**Consultation Response from KC,
Lead Local Flood Authority**

2025/93088 Wappy Springs Inn, Lindley Moor Road, Lindley Moor, Huddersfield, HD3 3TD

Discharge of details reserved by conditions 5 (C(E)MP), 6 (CEMP), 7 (surface water drainage), 8 (temp drainage), 9 (oil interceptor) on previous permission 2024/92553 for erection of mixed industrial development (Use Classes E(g)(ii, iii), B2 and B8); including demolition of existing structures, new yard, parking, landscaping, drainage features and ancillary structures

Date Responded: 8th December 2025

DRAWING NO. 20392-DCE-XX-XX-D-C-101 REV. 03

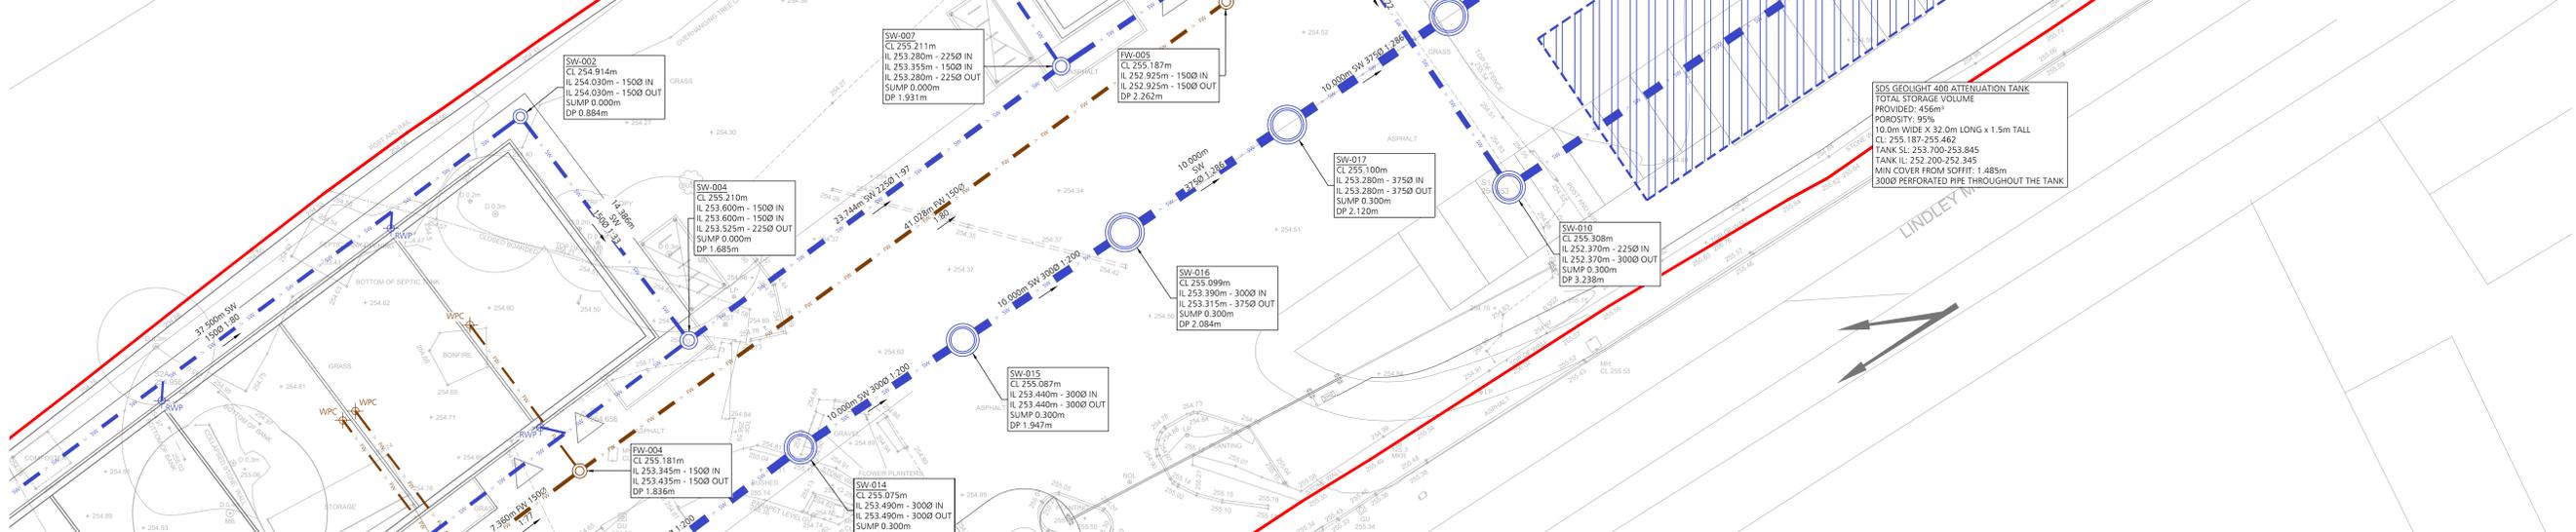
Full details of the tank, including plan and cross section, especially noting any drainage channels and access features for inspection and silt prevention are required. Unless a guarantee over longevity is stated or an independent assessment such as a BBA certificate, Kirklees would look to a conservative approach to replacing the crate storage that cannot be effectively cctv'd for periodic structural assessments. This would be a replacement every 25 years.

An interceptor is shown on drainage plans and a manufacturers brochure has been included in the submission. The plan should show the selected interceptor to demonstrate flow rates have been considered in sizing the specific model.

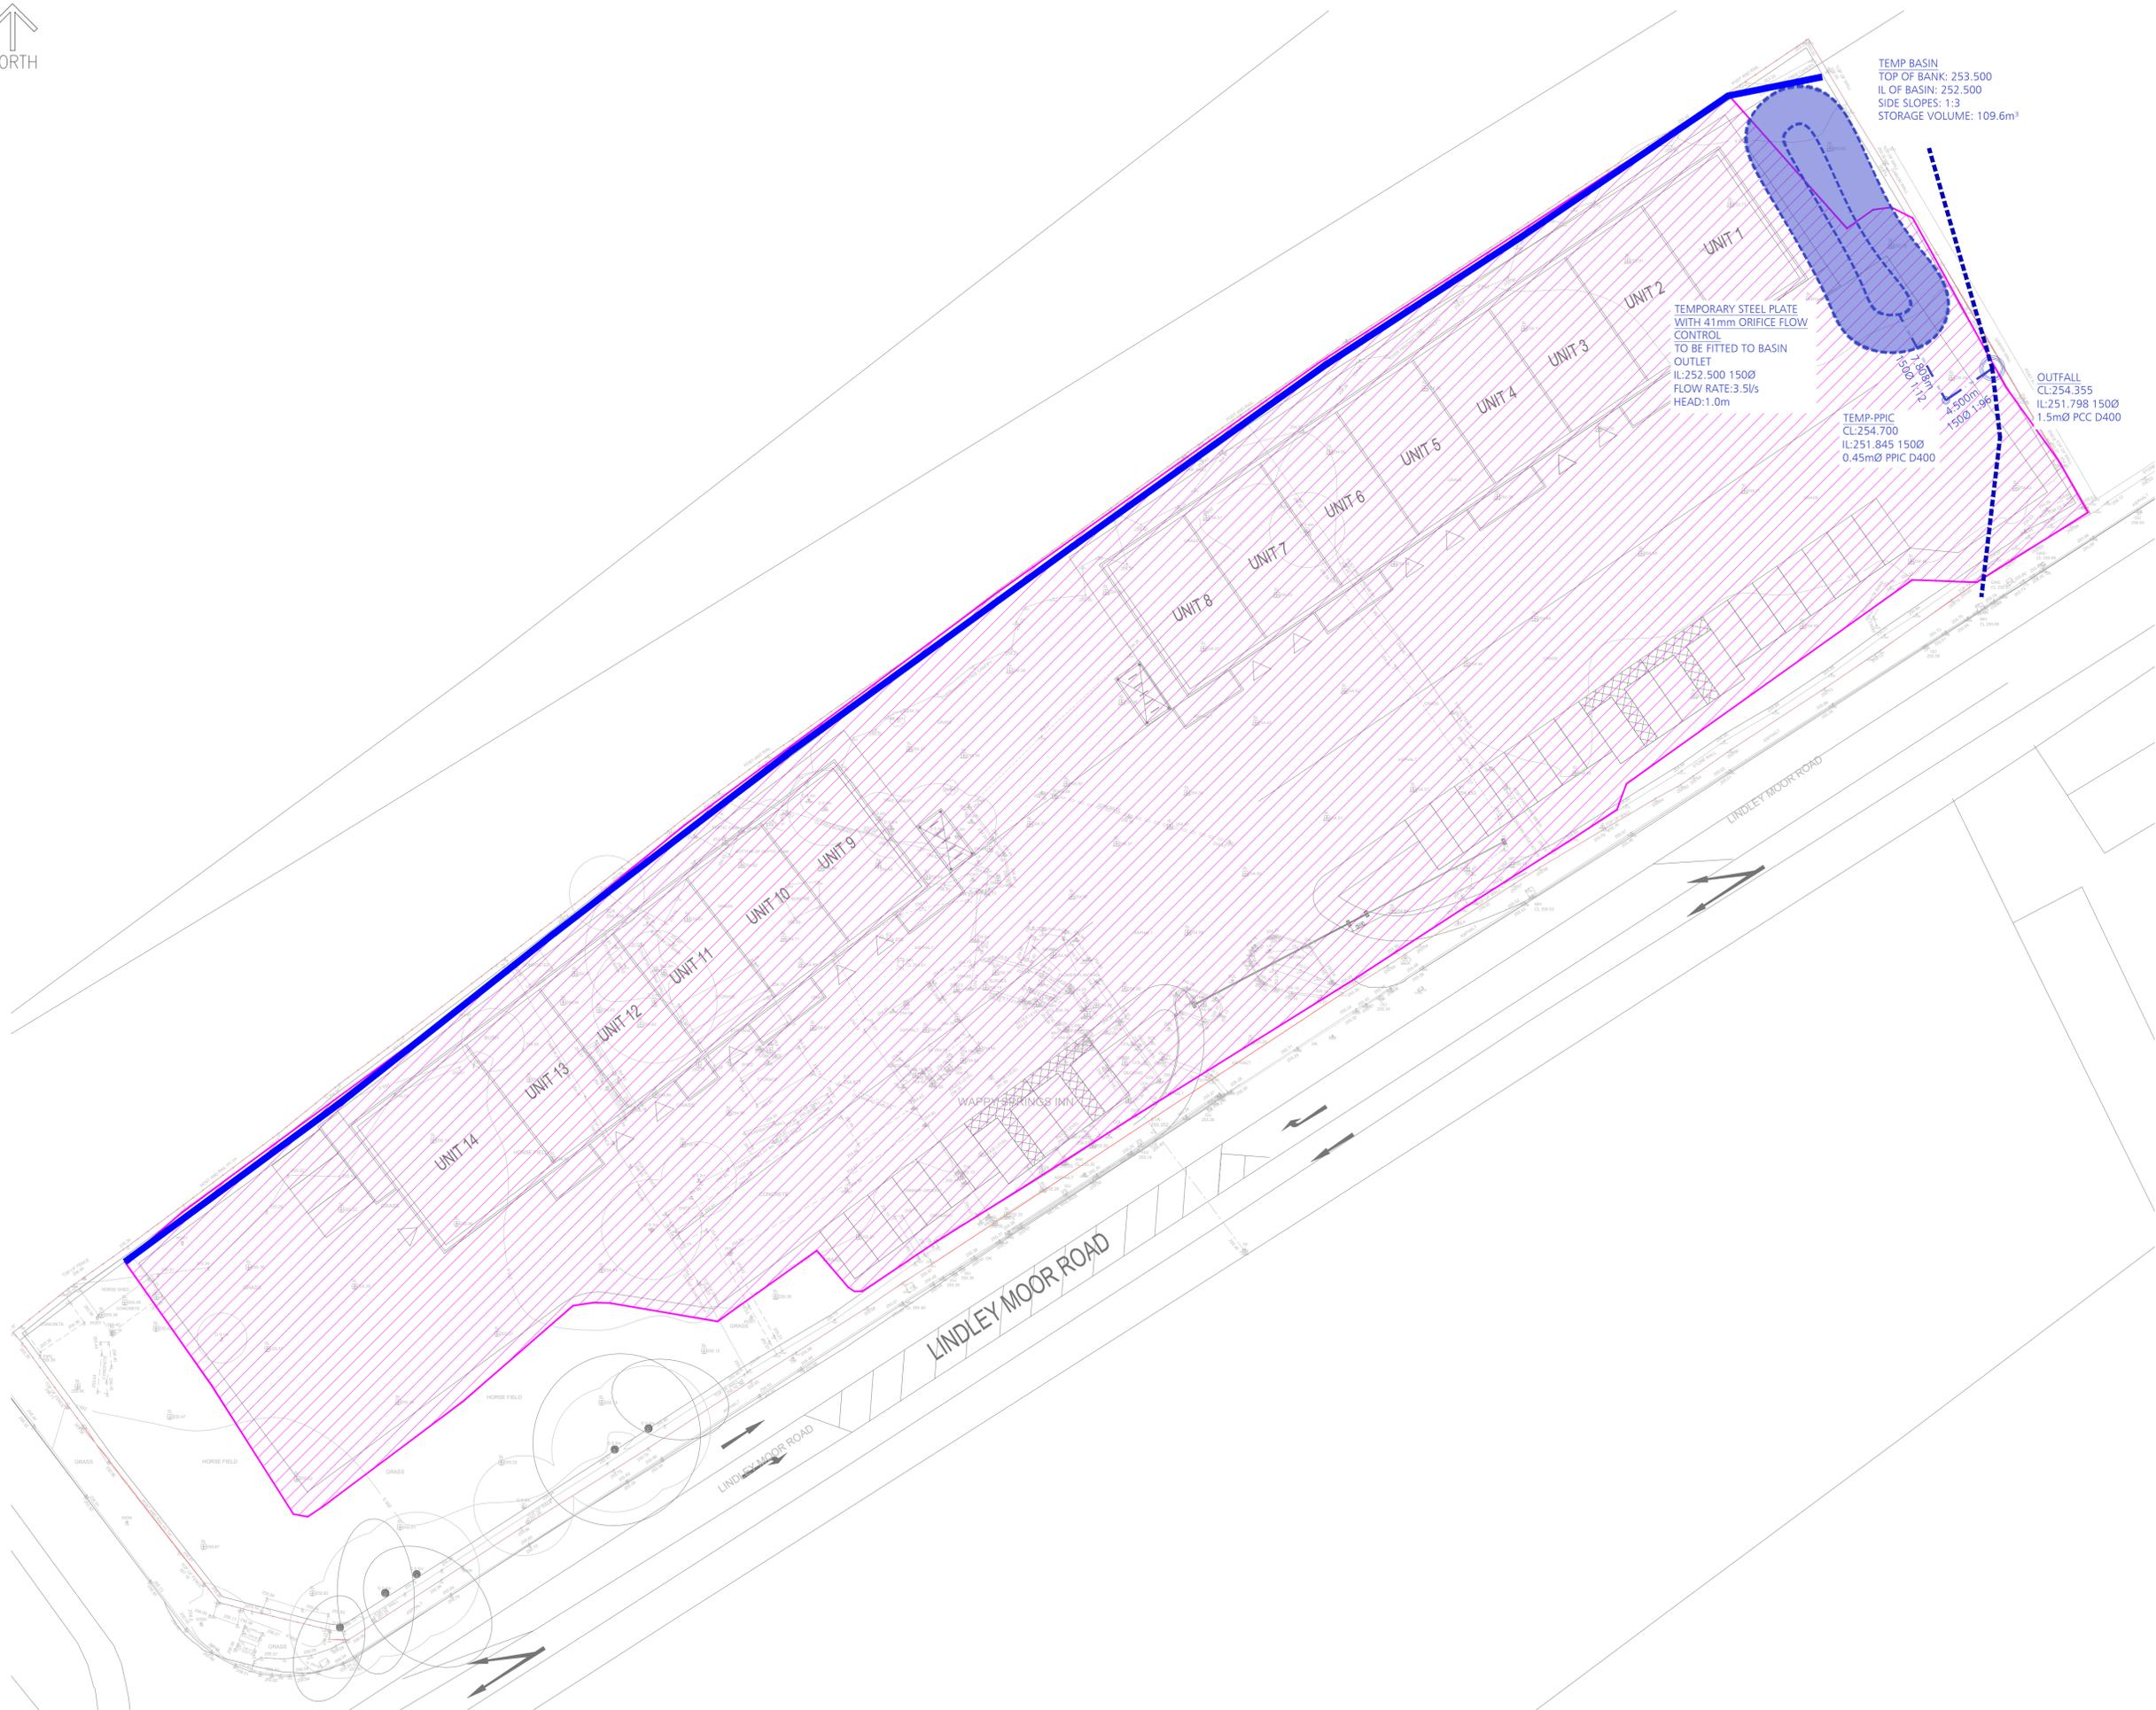
No temporary drainage plan has been submitted.
